From: Charlotte Easton
Sent: 11 March 2019 13:22
To: Karen Parsons
Subject: FW: 9 Orchard Way, Walberton - WA/113/18/HH

Subject: 9 Orchard Way, Walberton - WA/113/18/HH

I am the case officer on the application at WA/113/18/HH at 9 Orchard Way.

Orchard Way. Fontwell

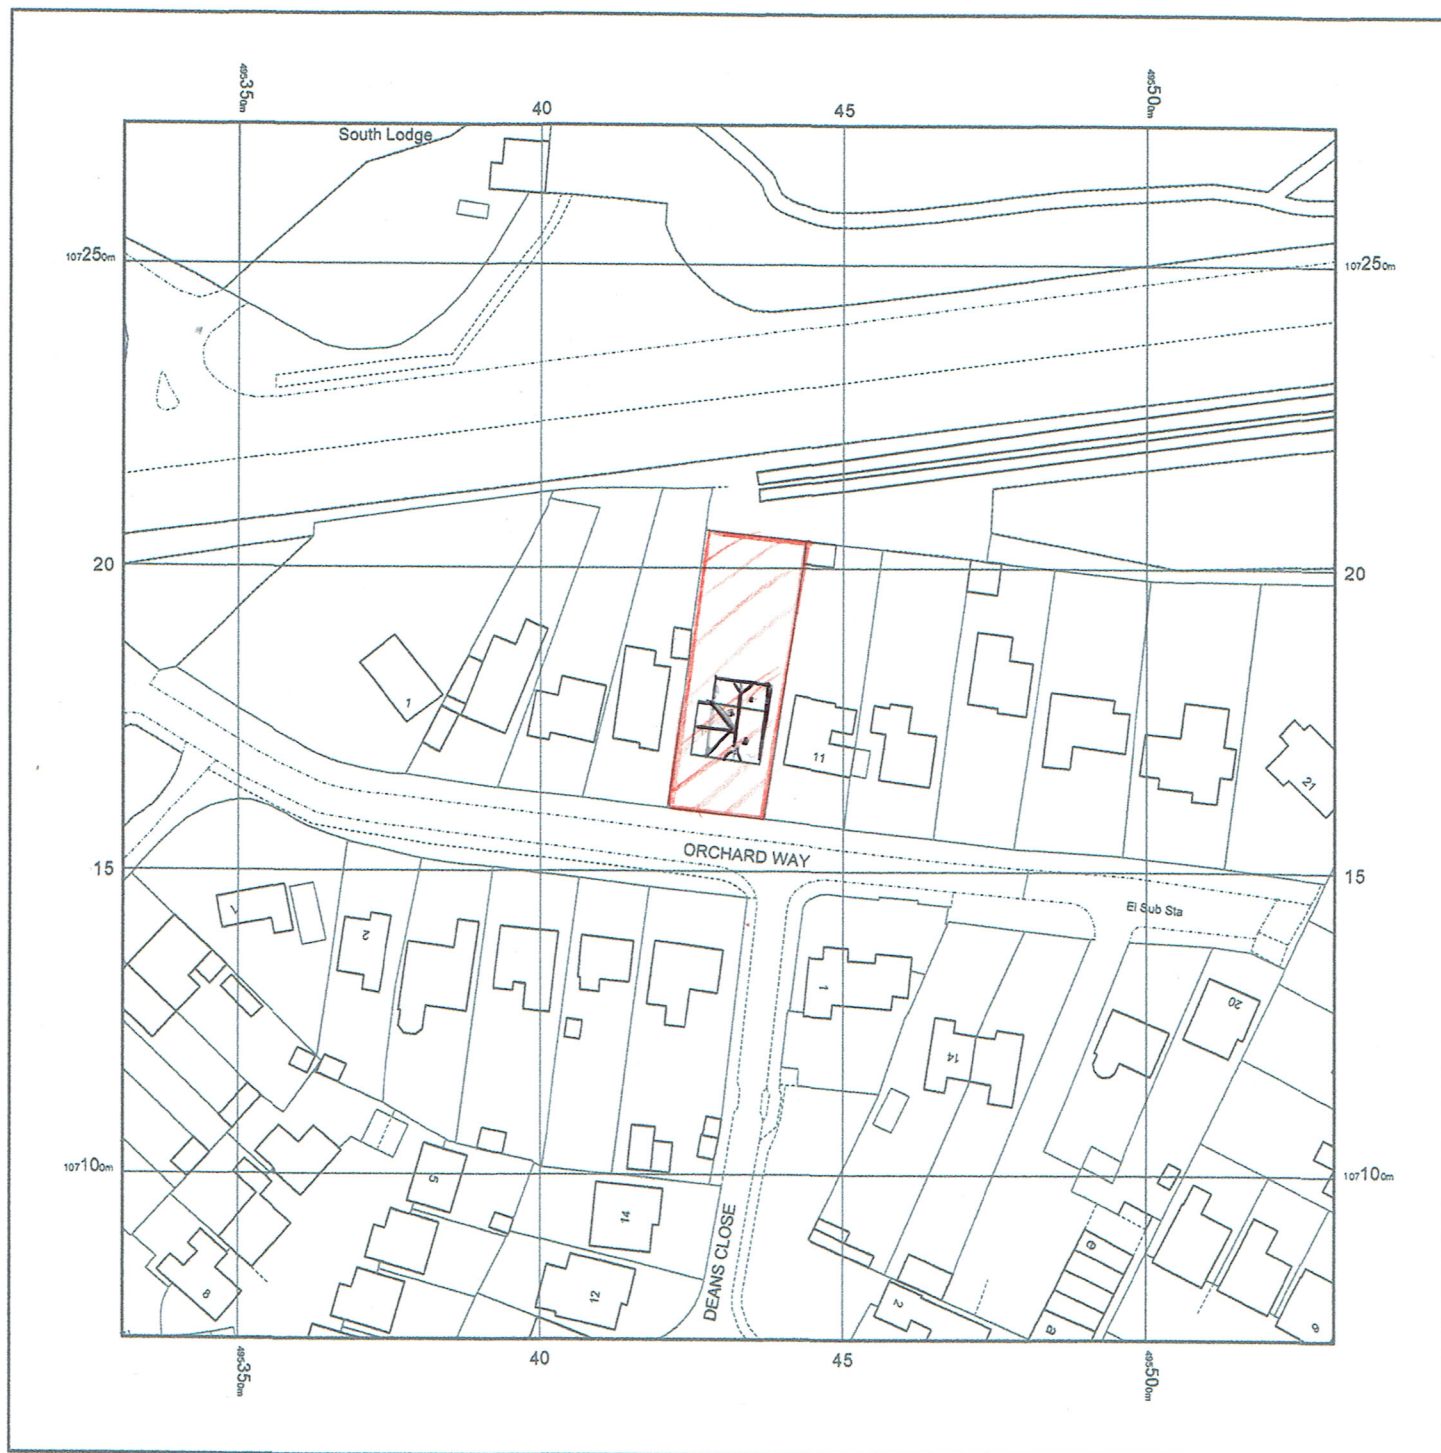
I am writing to request an amended block plan. I believe the existing block plan shows the rear extension to a depth of 4m whereas the application appears to reduce the depth to 3m. I believe this block plan was the same one used on the previous application however the rear extension appears to have been reduced since then and therefore needs to be amended.

Sorry! Attached new O/S Map.
Regards

Proposed Roof Plan

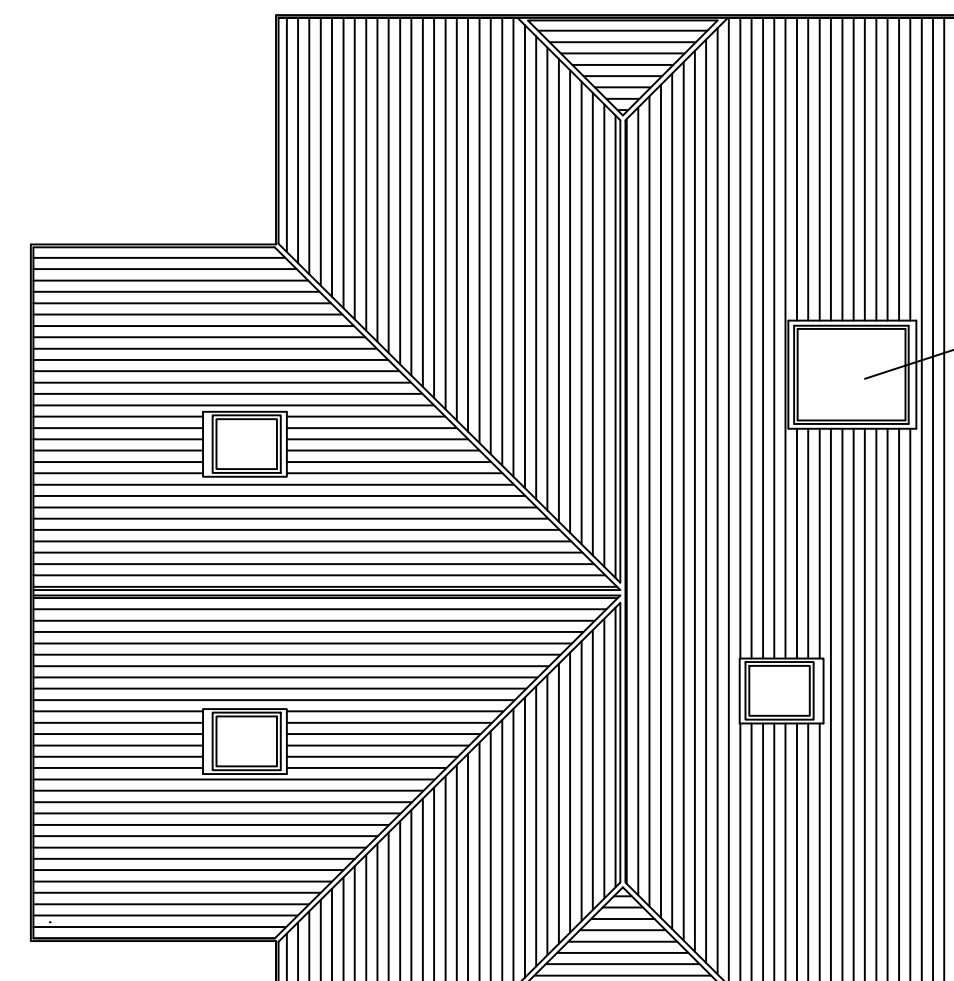
Please may you also mark on the additional Velux to the eastern elevation.

I note there is a Velux window for escapement to the eastern elevation. On assessment I believe due to its siting this could lead to adverse overlooking to the rear garden of the neighbouring property to the east. A condition will therefore be included which would fix shut the window below 1.7m.
